Project Name: *

I-5507 - Interstate 485 improvements from I-77 to US 74 (Independence Blvd)

August 24, 2023

Subject: Request for Modification for Section 404 Regional General Permit No. 201902350 and Section 401 Water Quality Certification for the Interstate 485 (I-485) improvements from I-77 to US 74 (Independence Boulevard), Mecklenburg County, Division 10, TIP I-5507. Debit \$570.00 from WBS 43609.3.2.

PROJECT REFERENCE NO.	SHEET NO.
I-5507	50
RW SHEET NO.	
ROADWAY DESIGN ENGINEER	HYDRAULICS ENGINEER
<p>DOCUMENT NOT CONSIDERED FINAL UNLESS ALL SIGNATURES COMPLETED</p>	
 BLYTE

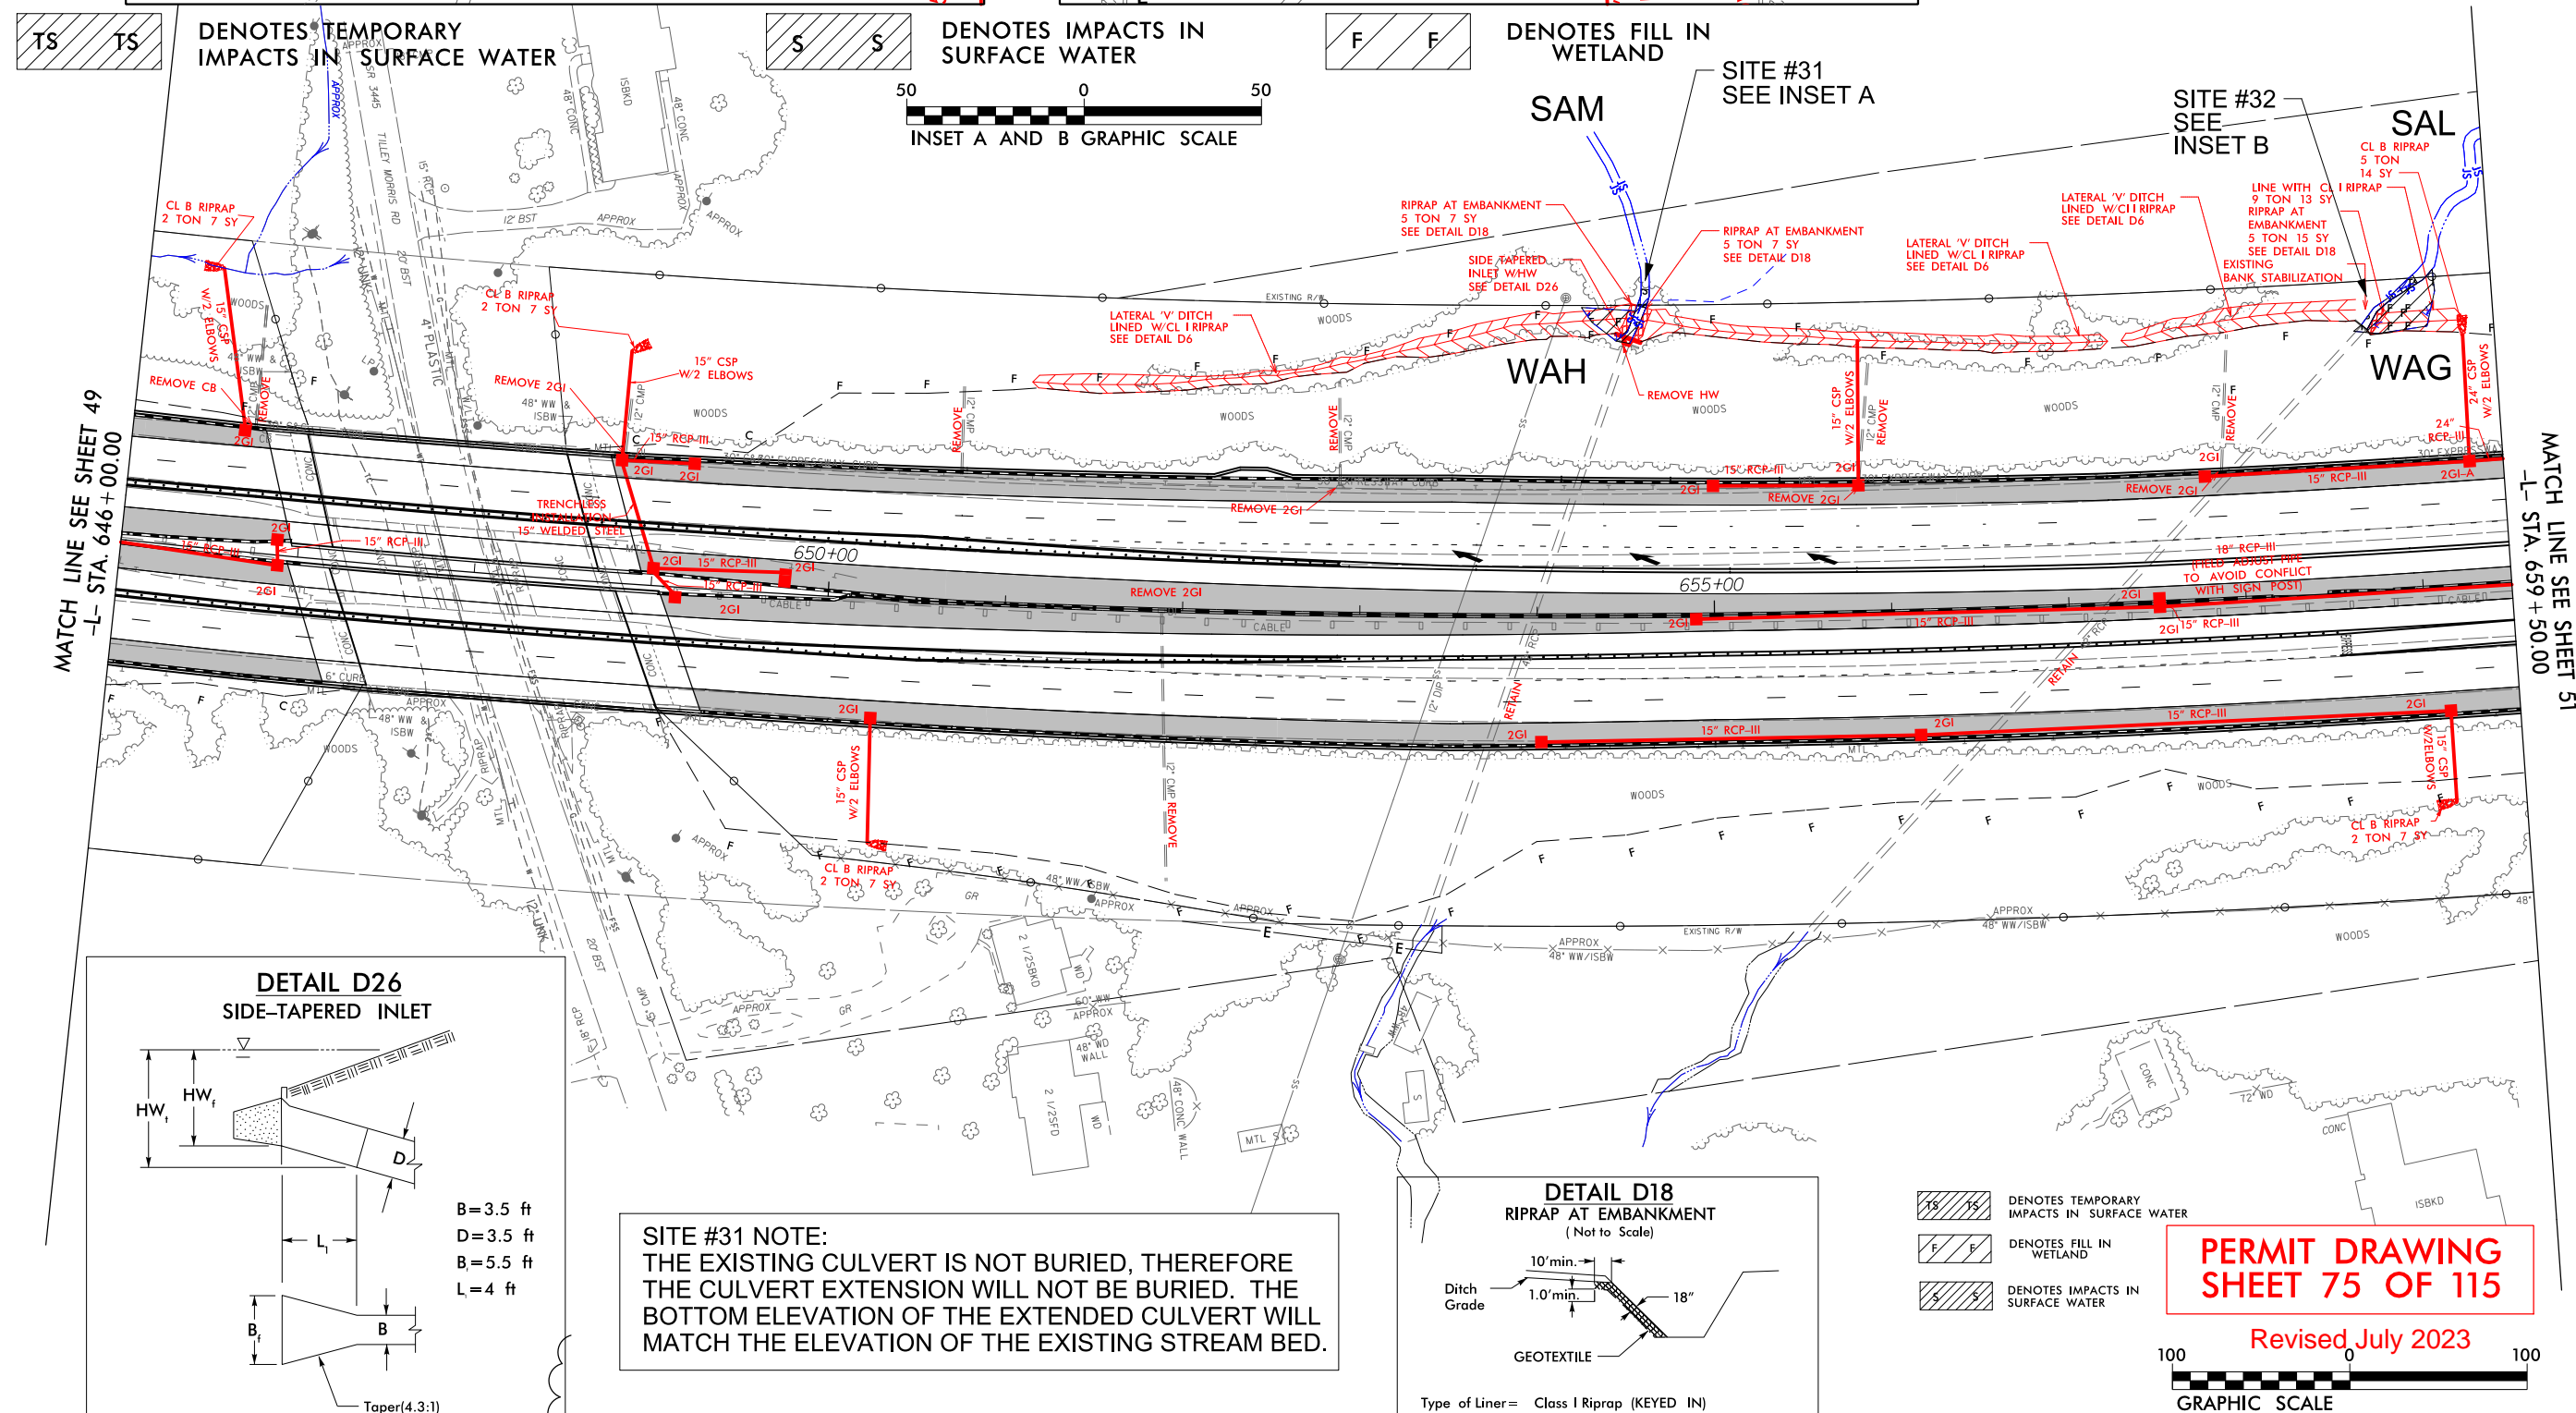
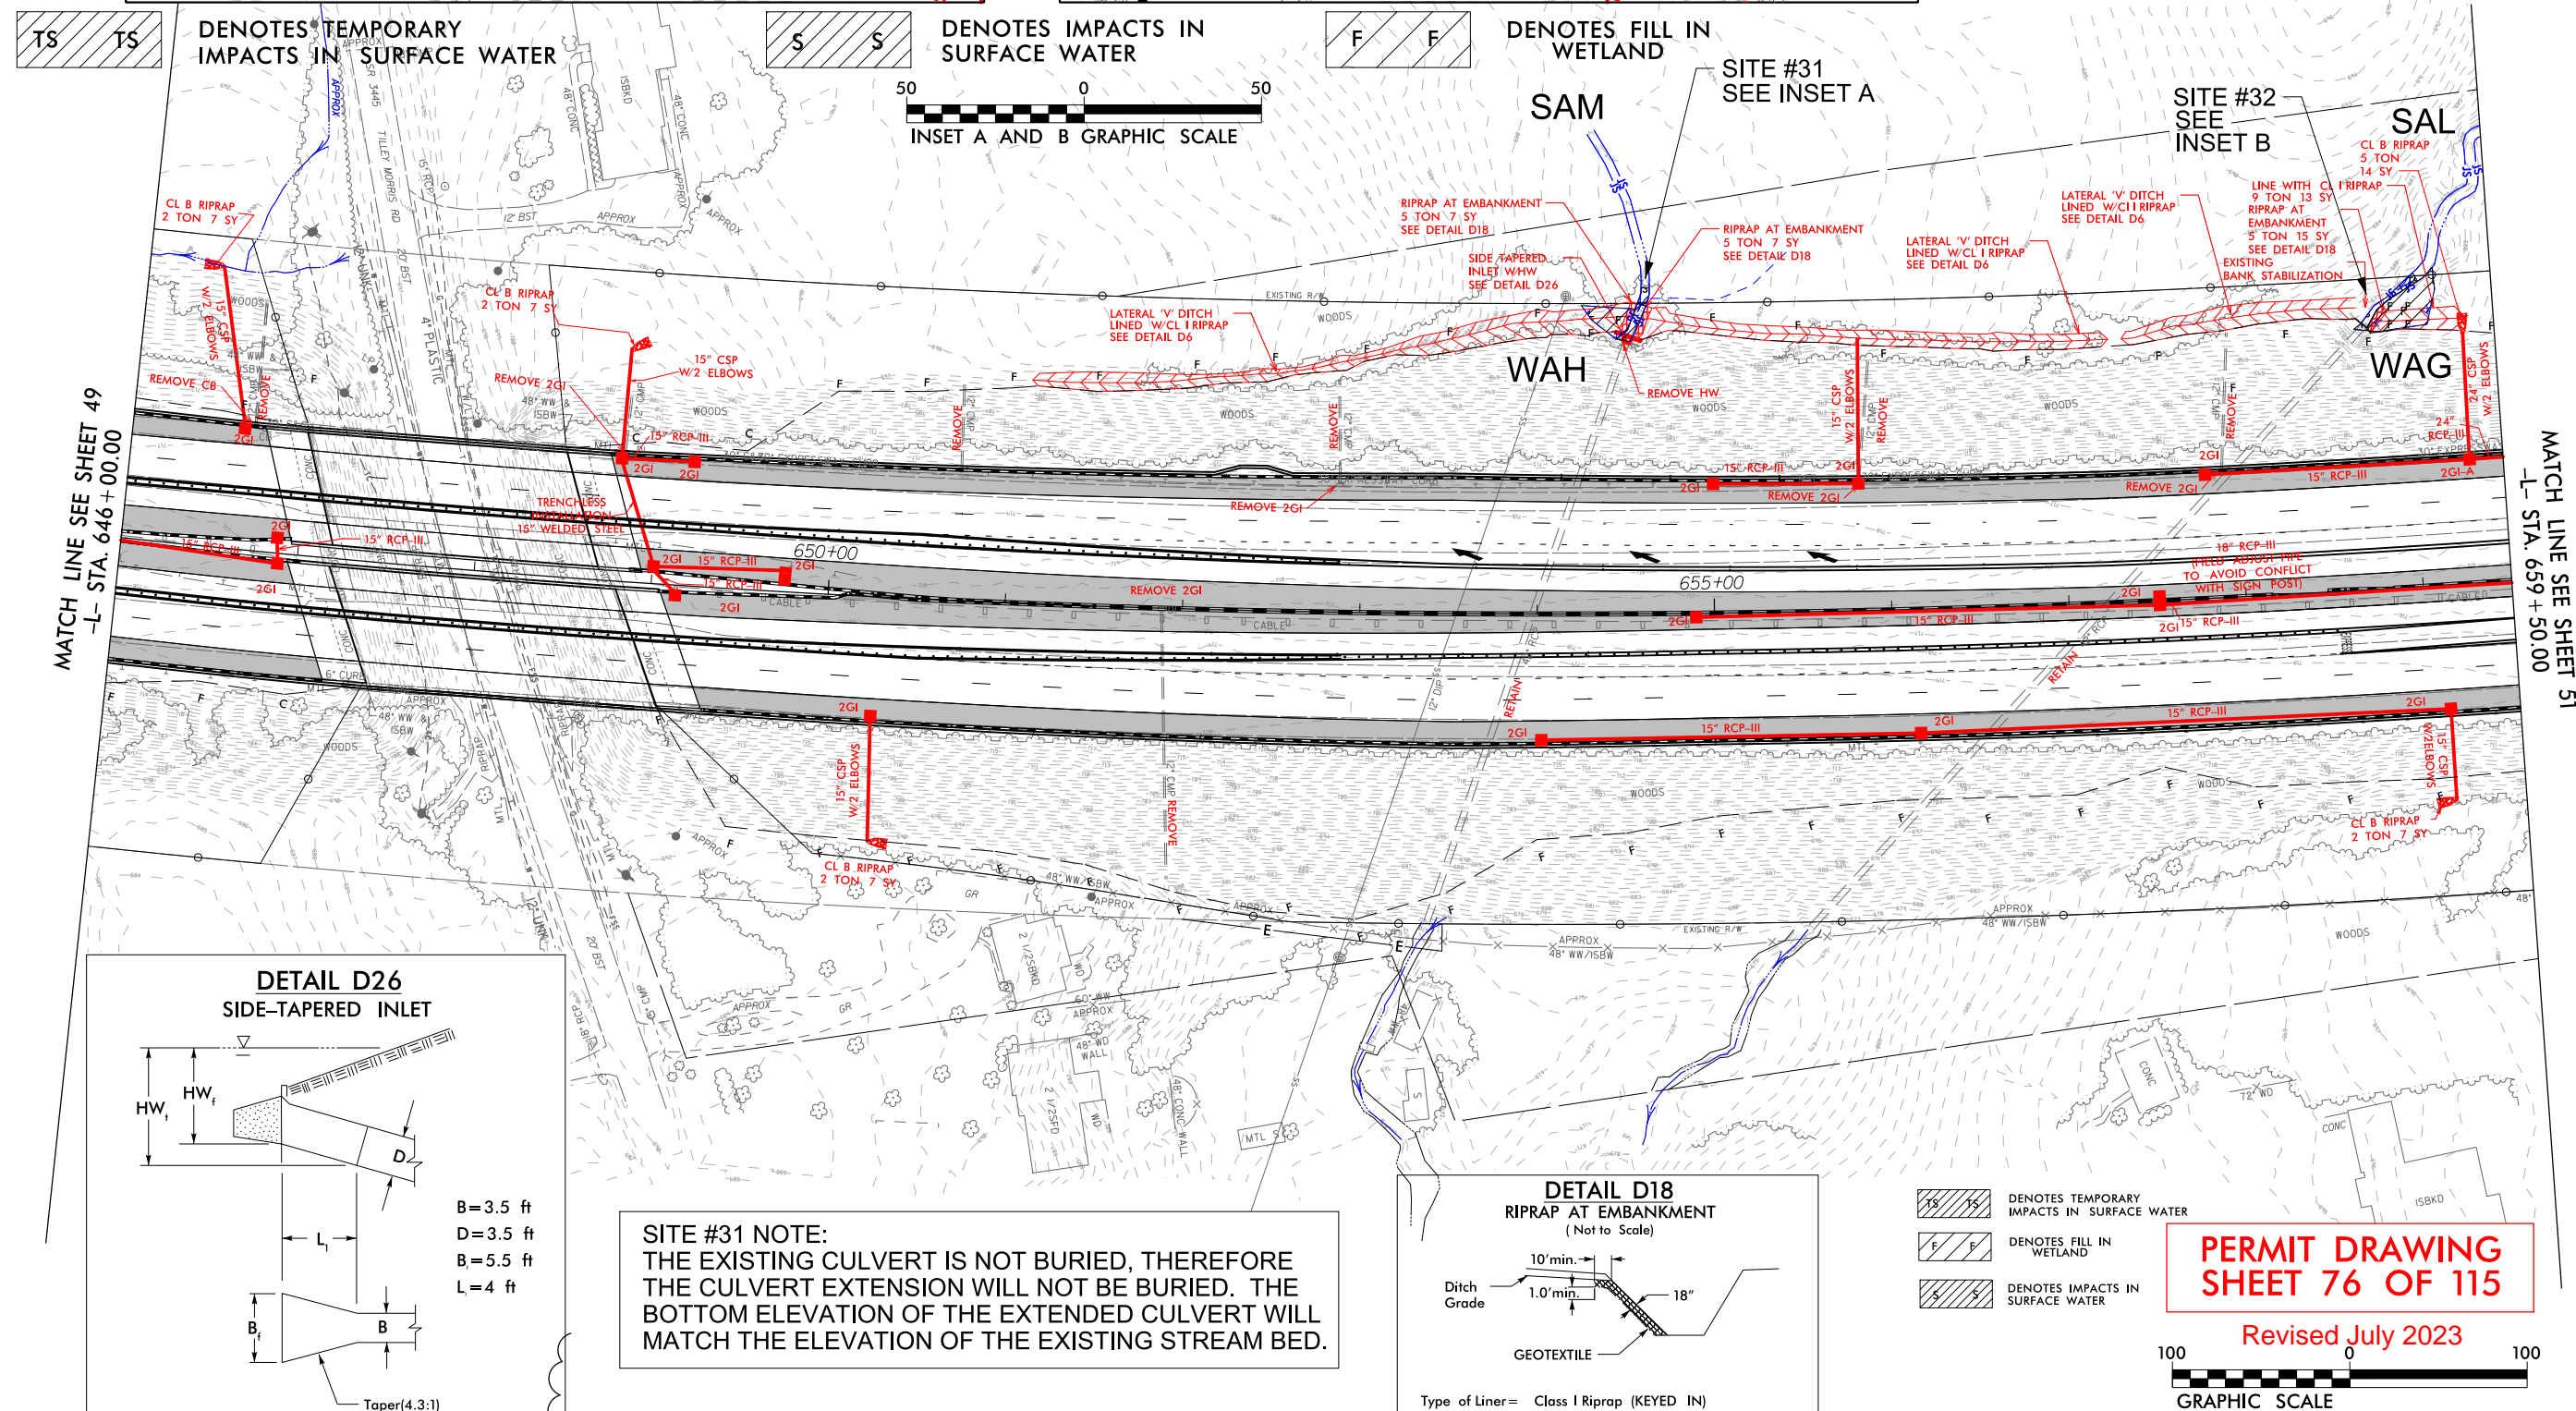
Site 32

The original approved impacts at Site 32 included 6 linear feet of stream bank stabilization, 20 linear feet of temporary stream impacts, and 0.02 acre of permanent wetland fill impacts associated with roadway fill and a storm water outfall tie-in. The drainage design has been revised at this site to add lateral ditches. The lateral ditch from the west will discharge prior to an existing riprap bank and will not result in impacts to the right bank. The lateral ditch from the east will drain to a proposed riprap bank, resulting in 15 linear feet of stream bank stabilization impact, 24 linear feet of temporary stream impacts, and 0.02 acre of permanent wetland fill impacts.
